**Rampion 2 Wind Farm
Category 8: Examination
Documents
Applicant's Responses to
Brighton and Hove City
Council's Deadline 1
Submissions
Date: March 2024
Rev A**

Application Reference: 8.48
Pursuant to: The Infrastructure Planning (Examination
Procedure) Rules 2010, Rule 8(1)(c)(i)
Ecodoc number: 005118964-01

Figure 15.33i  
 Viewpoint 8: Brighton sea front promenade

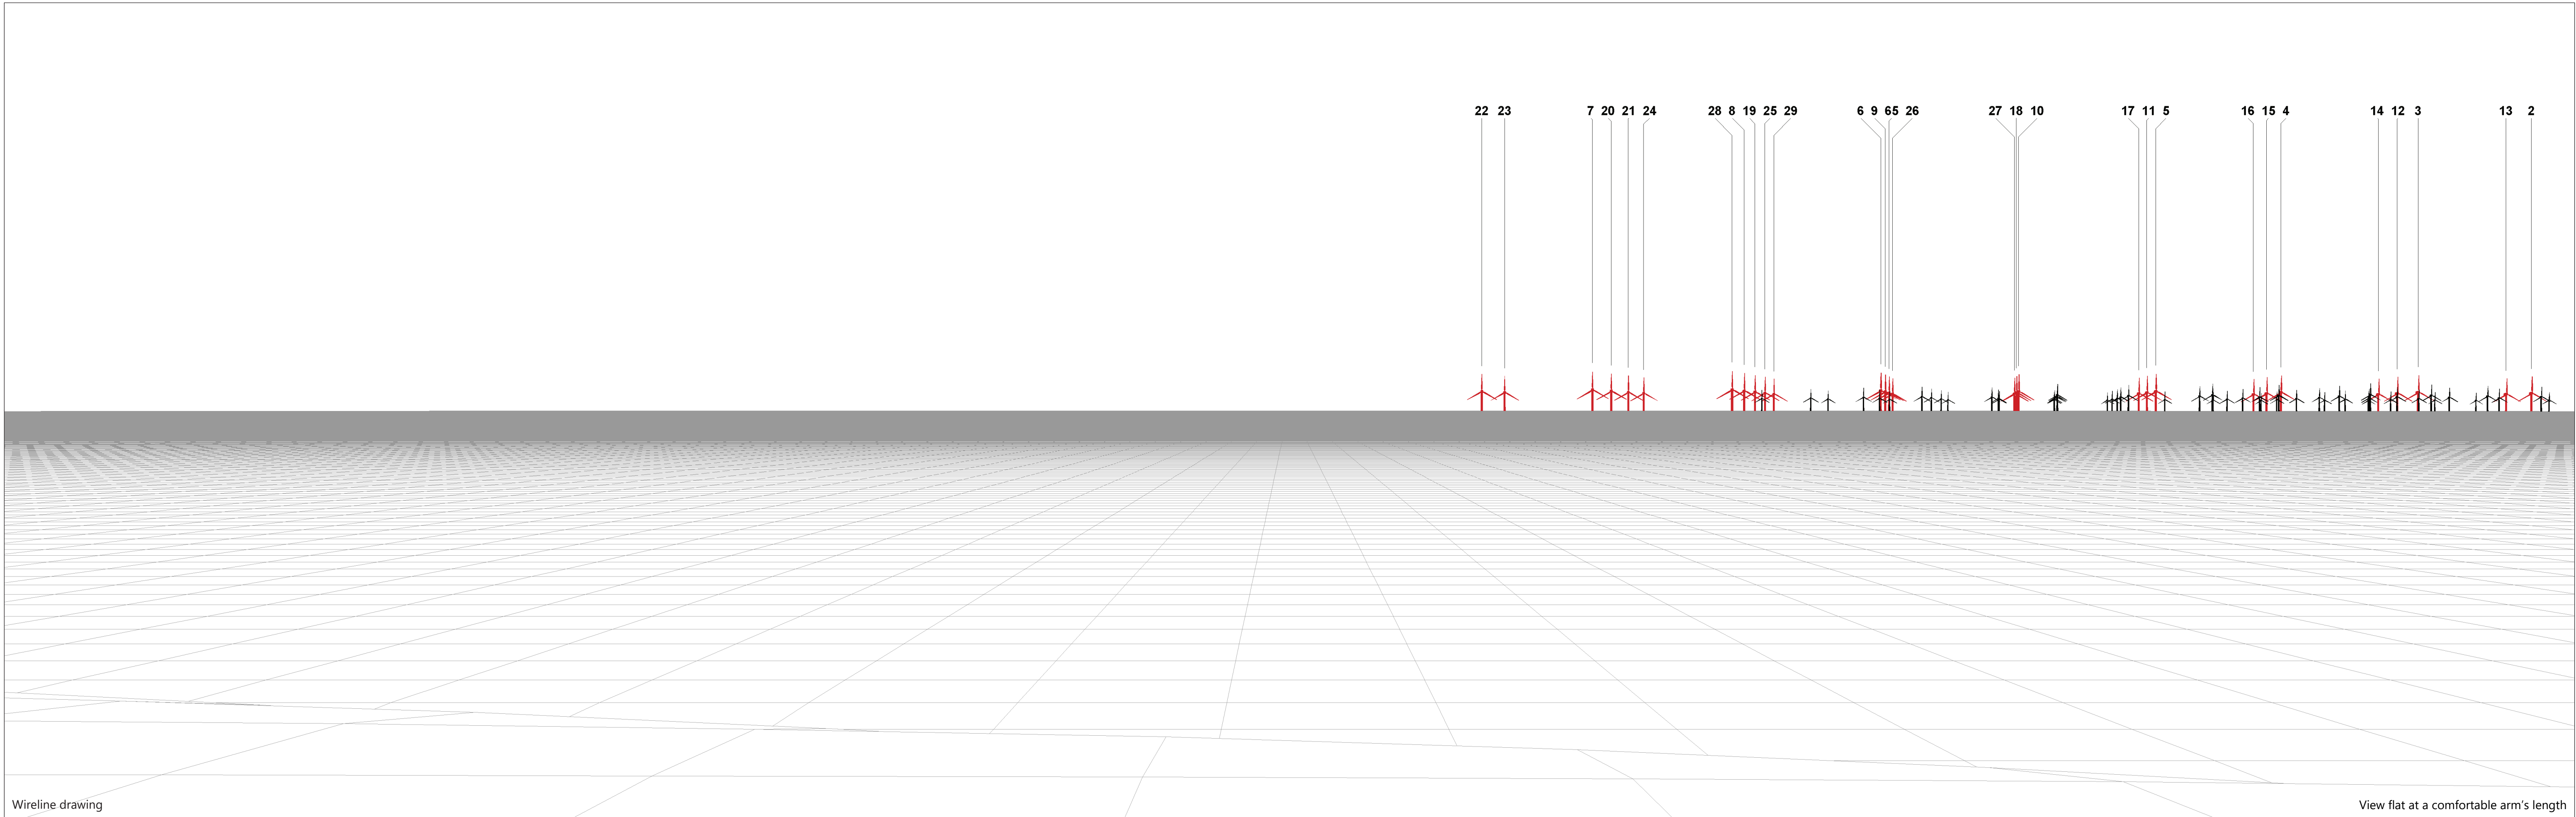
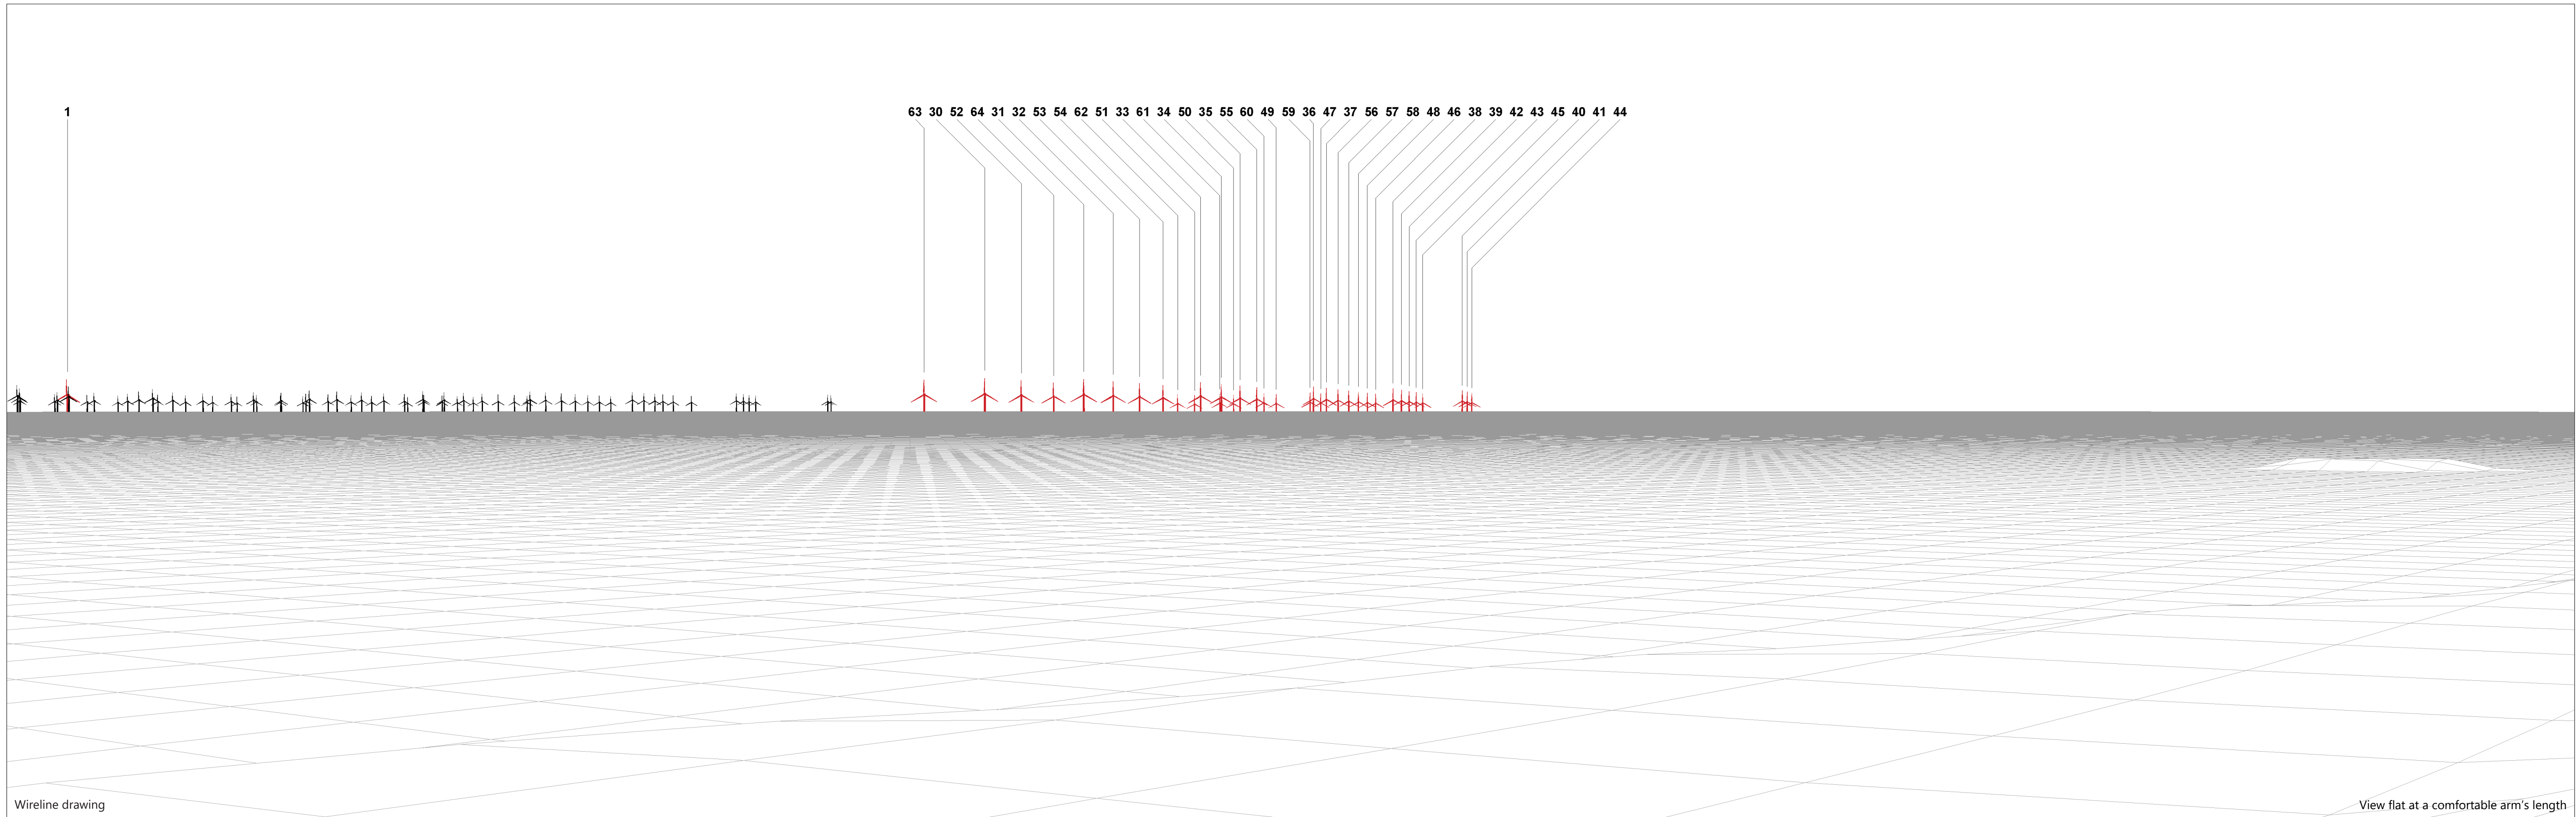
4.9	<p>4.9 As is clear from the photomontages provided, particularly viewpoint 8, Rampion 2 will mean that the horizon, when viewed from Brighton and Hove, is dominated by wind turbines. The seascape and experience of the City's coastline will be significantly changed for a significant period of time. While it would be for a 'temporary' period, thirty years operation after 4 years'</p>	<p>The seascape and visual effects of Rampion 2 wind turbine generators (WTGs) are assessed in Chapter 15: Seascape, landscape and visual impact assessment, Volume 2 of the ES [APP-056]. The Applicant notes that significant effects on views experienced by people living and visiting Brighton and Hove have been identified at viewpoints on the Brighton seafront (Viewpoint 8) and elevated areas of the city set back</p>

4.11 to 4.12	<p>4.11 However, this impact has been assessed from the single viewpoint (viewpoint 8) along Brighton and Hove’s 11km coastline. There are two other viewpoints within Brighton and Hove, both within the less populated areas of the SDNP. Assessment of the impact on the city’s urban areas, including the largest population centre along the coast, and the tens of millions of visitors to it is therefore dependent on a single viewpoint.</p> <p>4.12 It is worth noting that we highlighted this in our response to the PEIR submission in which we highlighted that we did not consider the location chosen to be representative of a ‘worst case scenario’ or Rochdale Envelope approach in terms of the impact on the city, and thus the impact has been underassessed:</p> <p><i>“The Brighton seafront view (Viewpoint 8) has been taken from the Kings Road between the two piers. This is a comparatively low-lying viewpoint and the seafront here is very developed and has a busy commercial and tourism character. As a result, the impact of the offshore array in this viewpoint has been under-assessed.</i></p> <p><i>In landscape and seascape terms, a more representative location would be from an elevated position towards the eastern end of Marine Parade. The seafront is much more open and tranquil in this area, and uninterrupted sea views are integral to the way to the way this historic area is experienced, so the magnitude of change arising from the offshore array will likely be greater.”</i></p>	<p>The effect of the Proposed Development on views from Brighton and Hove is assessed at three representative viewpoints within the Brighton and Hove boundary - Viewpoint 7 Beacon Hill (Figure 15.32, Volume 3 of the ES [APP-091]), Viewpoint 8 Brighton Seafront (Figure 15.33, Volume 3 of the ES [APP-091]) and Viewpoint 27 Hollingbury Hill Fort (Figure 15.50, Volume 3 of the ES [APP-093]). Although it is noted that Viewpoint 7 and 27 are also within the South Downs National Park (SDNP), viewpoints were intended to represent both the Brighton seafront area (Viewpoint 8), as well as views along the coast over Brighton from the east (Viewpoint 7) and elevated areas of the city set further back from the coastal edge on the edge of the SDNP (Viewpoint 27), to illustrate the range of effects occurring on the setting of the city. The Applicant notes that Brighton and Hove City Council wishes to see a further viewpoint assessed from an elevated position towards the eastern end of Marine Parade. As noted in Chapter 15: Seascape, landscape and visual impact assessment, Volume 2 of the ES [APP-056] (Table 15.7), detailed consultations were undertaken on the viewpoints selected through the statutory and non-statutory consultations, which brought forward many suggestions from stakeholders regarding the inclusion of certain viewpoint locations for assessment. In total 54 viewpoints (Table 15-14) were agreed with the expert topic group ‘ETG’ and included in the SLVIA, which provide a wealth of representative locations from which to understand the likely significant effects of the Proposed Development.</p> <p>The Applicant notes Brighton and Hove City Council’s concerns that the residual effects on the City have been underassessed, however regardless of the precise siting of the viewpoint at the seafront, it would note the response above in reference 4.3 that the sensitivity and importance of the sea views from Brighton seafront and the contribution of the seascape to the city character and sensation of space within Brighton is recognised and assessed accordingly, as being of high sensitivity and the effect major (in</p>

4.14 to 4.20	<p>4.14 While the scheme has been amended since the PEIR stage, the point raised remains relevant. In BHCC's view, the impact of the scheme on the city's coastline has been underestimated because of the location chosen, notably a busy location between two piers – features that extend into the sea, enclosing the view.</p> <p>4.15 The applicant's description of the viewpoint reinforces this (SLVIA page 257): <i>"The immediate context of the sea view is fundamentally defined by the influence of the pier. Further foreground detail is contributed by the below promenade shops and beach recreational facilities along with the shoreline strip of shingle beach."</i></p> <p>4.16 This accurately describes the area in which viewpoint 8 is located. It is a busy location enclosed by the (grade II* listed) Palace Pier and to a lesser extent the (grade I listed) West Pier. This is not the case to the west and east of this point, where there are more tranquil locations less affected by the piers and less enclosed. Naturally, the Horizontal Field of View would be less in this location than it would in other locations at a higher level or one not located between two seaward structures.</p>	<p>Please see responses provided in references 4.7, 4.8, and 4.11 to 4.12 above.</p>

The design principles described in Section 15.7 of **Chapter 15: Seascape, landscape and visual impact assessment, Volume 2** of the Environmental Statement (ES) **[APP-056]** have contributed to reducing the magnitude of change on views from Brighton seafront (Viewpoint 8) and Rottingdean (Viewpoint 7) from ‘High’ magnitude assessed in the Preliminary Environmental Information Report (PEIR) published as part of the first

Ref	Local Impact Report comment	Applicant's Response
	<p>construction is a significant temporal impact by any measure, and would be in addition to the impact already experienced as a result of Rampion 1.</p>	<p>from the coast (Viewpoint 27). The spatial extent of the Rampion 2 array area has been reduced and designed according to a set of SLVIA specific design principles (Section 15.7 of Chapter 15: Seascape, landscape and visual impact assessment, Volume 2 of the ES [APP-056]) which have reduced the magnitude of effects and minimised harm to perceived seascape qualities and views. As described above in reference 4.8, these have contributed to reducing the effect of the Project on views from Brighton and Hove. Opportunities to reduce effects further are limited by the technical, economic, and functional requirements of the Proposed Development to produce renewable energy, as well as other environmental factors as presented in the final array area extent in the Offshore Works Plan [PEPD-004].</p>
